To Protect and Promote the Health and the Environment of the People of Kittitas County

To: All Staff
From: Environmental Health
Date: August 6, 2025
Subject: SPF-25-00004 Final Plat Review Comments

FAHLGREN SHORT PLAT
 PART OF SECTION 5, T. 17 N., R. 18 E., W.M.
 KITTITAS COUNTY, WASHINGTON

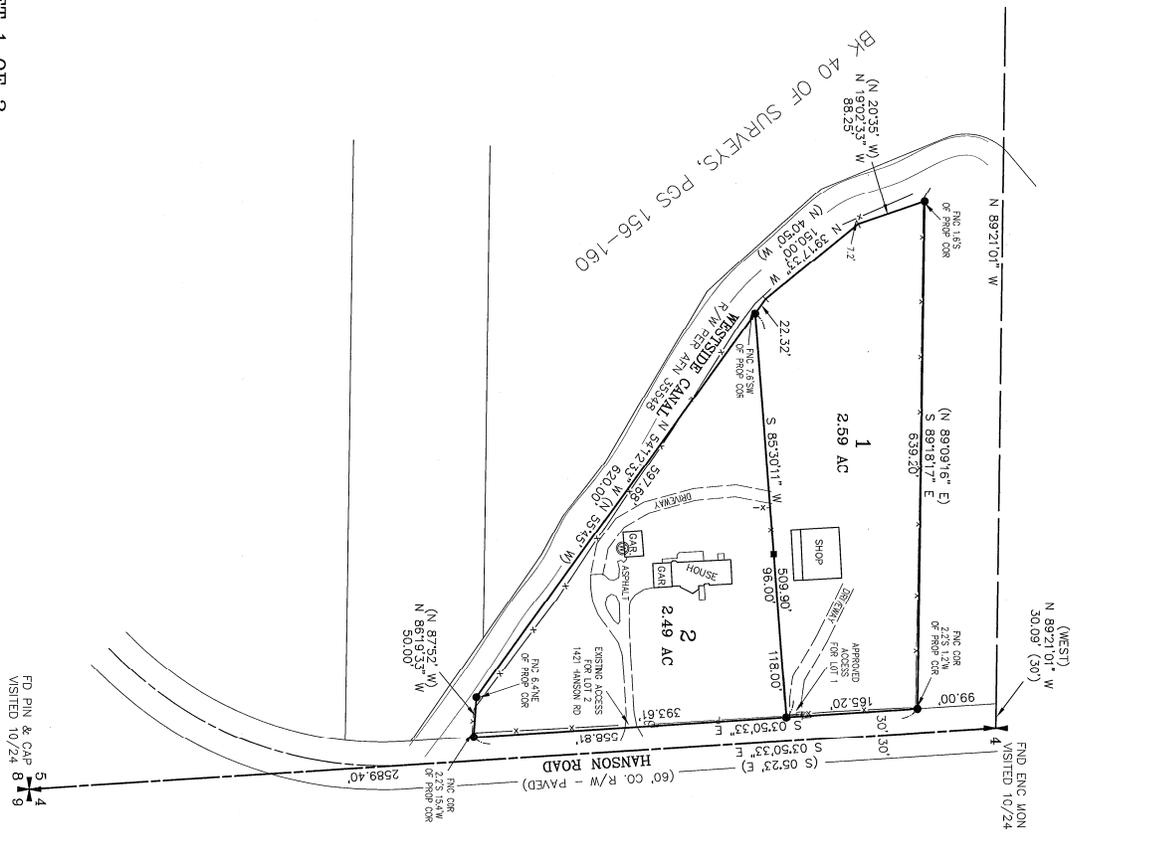
- The proposed shared well included in the final plat application does not include evidence of a 100-foot water supply protection zone as required by WAC 246-272A-0320(2)(iii).
- Soil logs on Lot 1 do not meet the minimum depth requirement of 36 inches.
